**RFI**

RFI #: 80  
Date: 3/20/2012  
Job: EB-02 Keller Springs Lofts  
Phone: 877-777-5115

Subject: Elevation conflict with floors

DATE	08-05-2011	SHEET NUMBER	3.4
PROJECT	11129

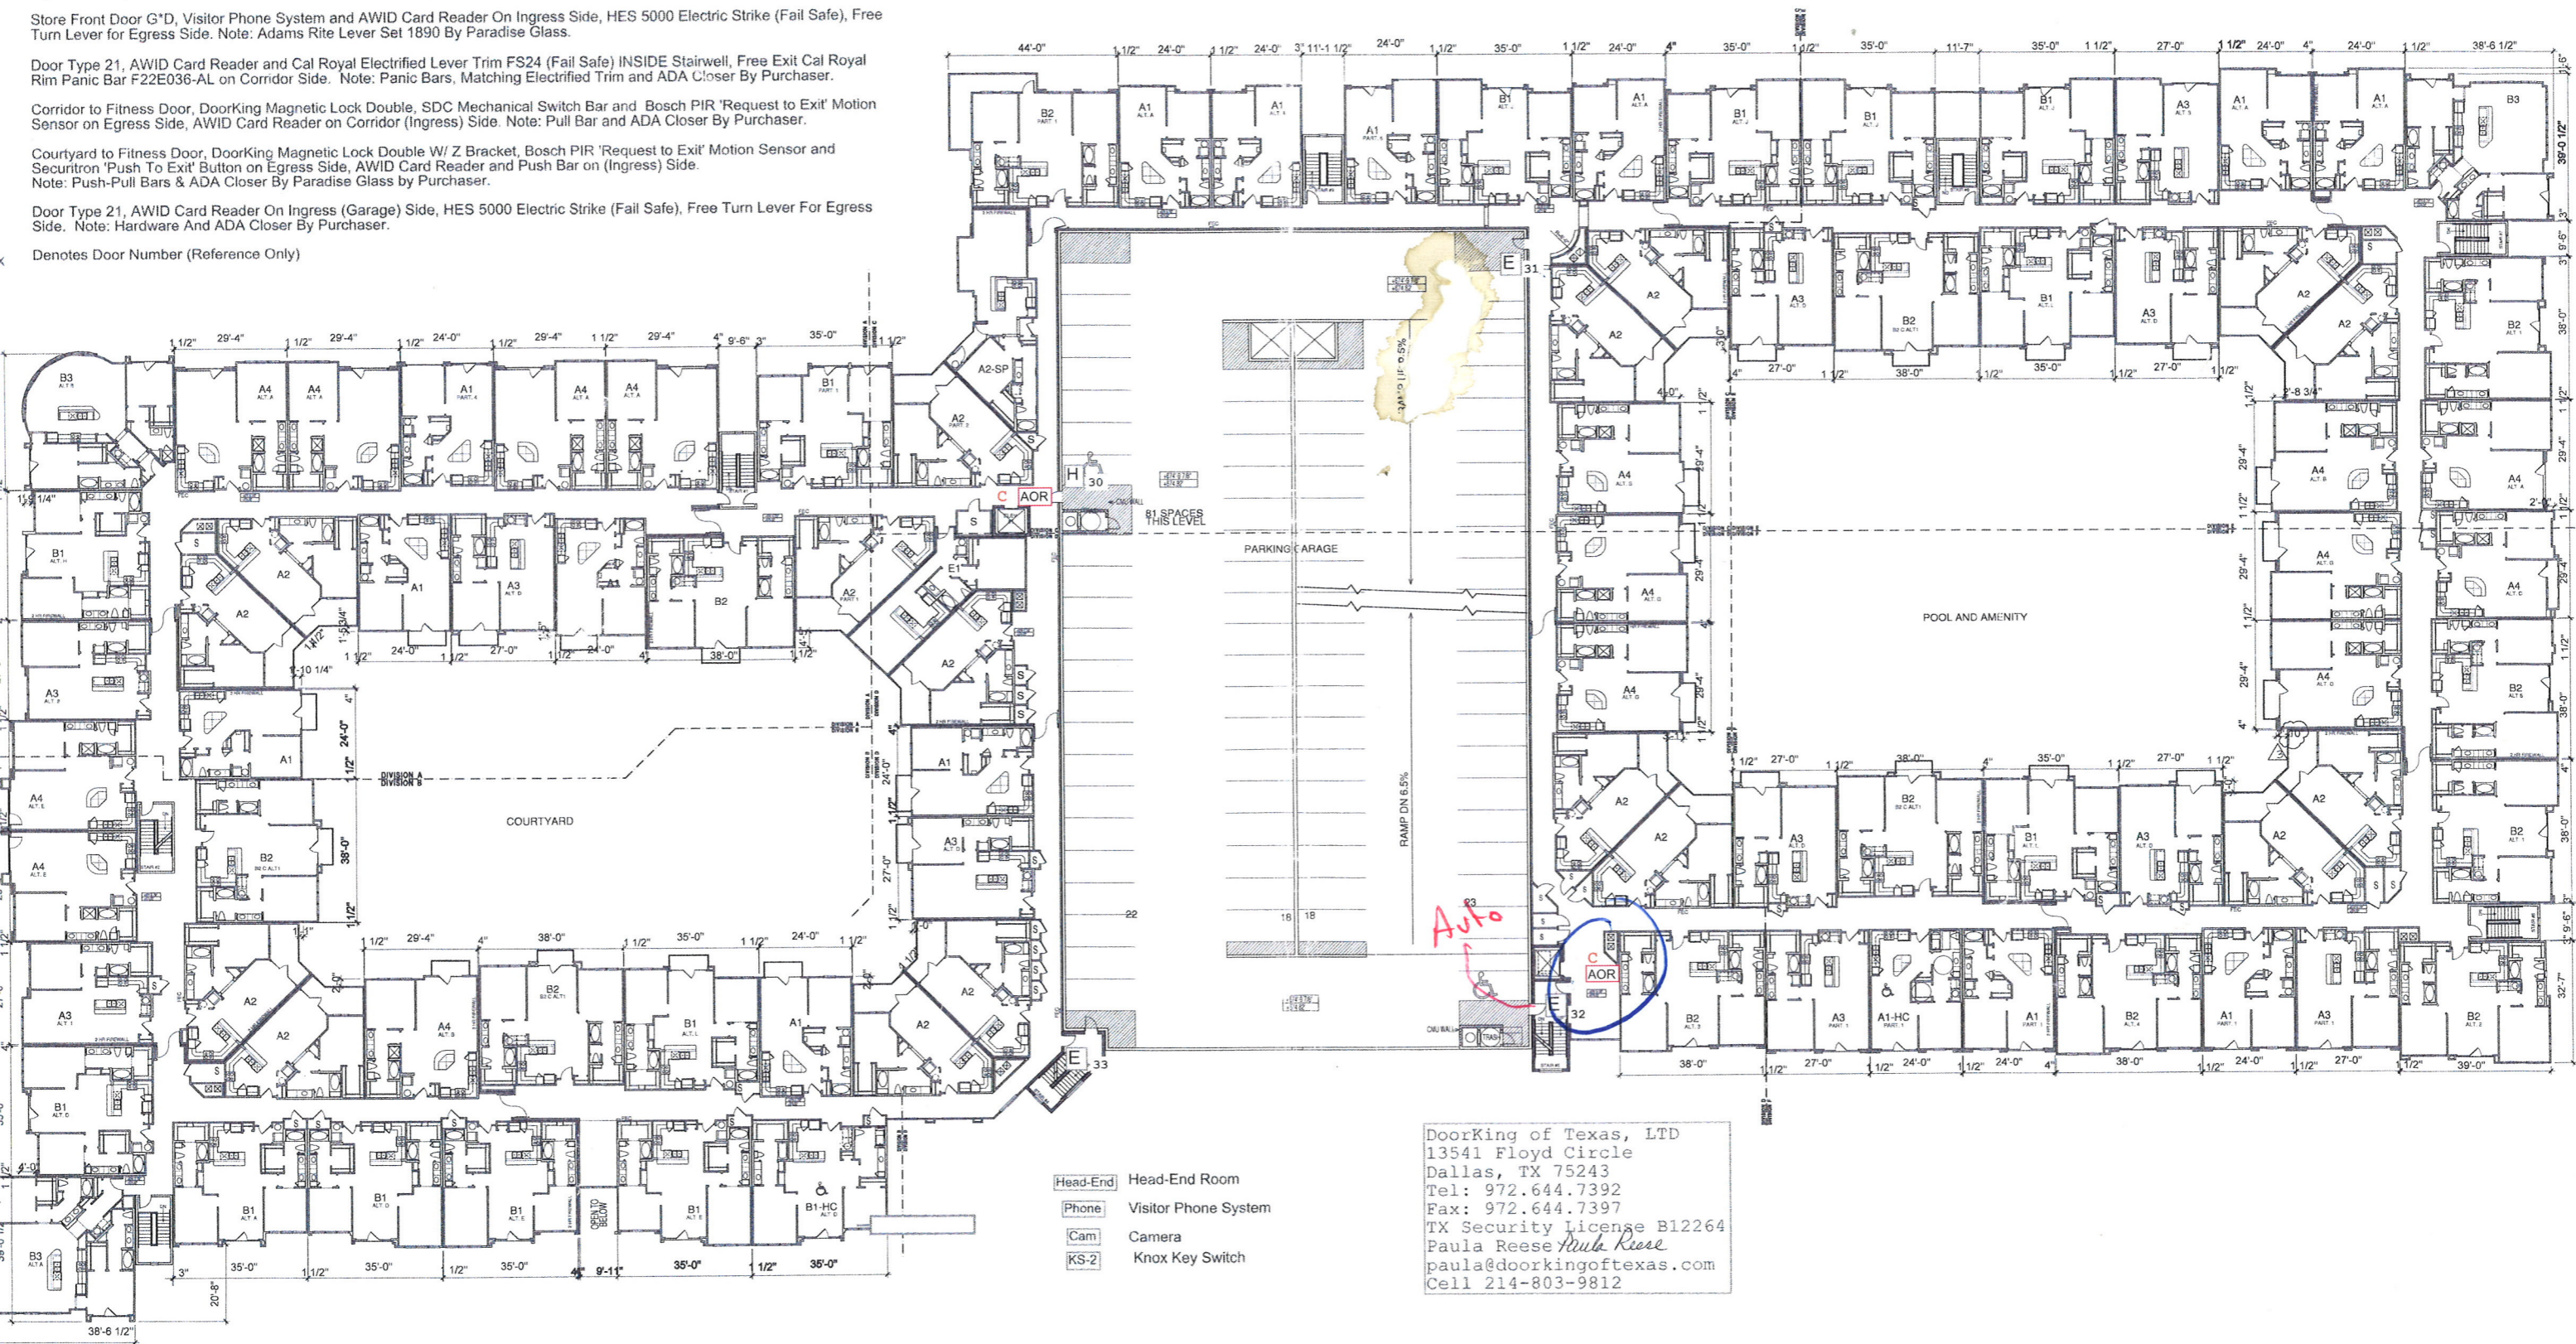
Thank you for addressing RFI #48. Your answer to #48 has us installing an additional 1x to the bottom plate to achieve specified elevations at 2nd 3rd and 4th floors around the parking garage. We do agree with adding the 1x to 2nd and 3rd floor bottom plates, but we think it should be to the entire 2nd and 3rd floors. The problem that we resolved around the garage is still present at the other stairwells. Here is a list of potential problems with installing the 1x to only parts of the floor

- 1 we will have step downs in the corridor ceilings
- 2 we will still have elevation problems at stairwell #s 1-2-3-5-7-8
- 3 floor plate differences at exterior elevations
- 4 the ramping of the floors (that you have addressed)
- 5 we will have to add a 1x to top of 4th to all areas not raised or field cut all of the studs in your shaded area to achieve proper roof truss bearing.

In summary we think that we should install the 1x to all of 2nd and 3rd floor bottom plates. Erik this was previously discussed with the Project Manager David Gallagher, the Project Super Brian Peterson and with you and agreed upon by all parties.

**Request:** Erik our framing subcontractor has an RFI. We think that there may be some discrepancies in the floor elevations that are shown on pages A3.1, A3.2, A3.3 and A3.4. We are basing this on the dimension 9'-1-1/8" (ceiling heights) that is shown for a section of 1st floor (page 3, 1e & 3, 1f) and is also given as the typical ceiling height for all 2nd 3rd and 4th floors. The 9'-1-1/8" ceiling height is a common / standard height for 9" walls and are constructed with (3) 1-1/2" plates and a 104-5/8" stud. With this being said our finish floor heights will be:

- 2nd floor 65'4"-1/16 (good)
- 3rd floor 65' 11-15/16 (1-1/16 inch low)
- 4th floor 67' 7-13/16 (2-1/16 inch low)

Typically on a wood framed building you can expect about a 1/2" of growth in height per floor. However this still will be short of your target elevations. Has the steel & stairs been put into production? Can the elevation be adjusted? If not we may need to look at the option of adding a 1x to 2nd and 3rd floor sills. I have attached a drawing for your review. This drawing shows the actual finish floor elevations using 3 plates and a 104-5/8" stud. Please advise.

**Response:** BGO agrees and has no exception to this change.

**Response:** Please add a 1x4 mudsill at 3rd and 4th floors as shown on sheets 3.3.1 and 3.4.1 (next pages of this PDF).
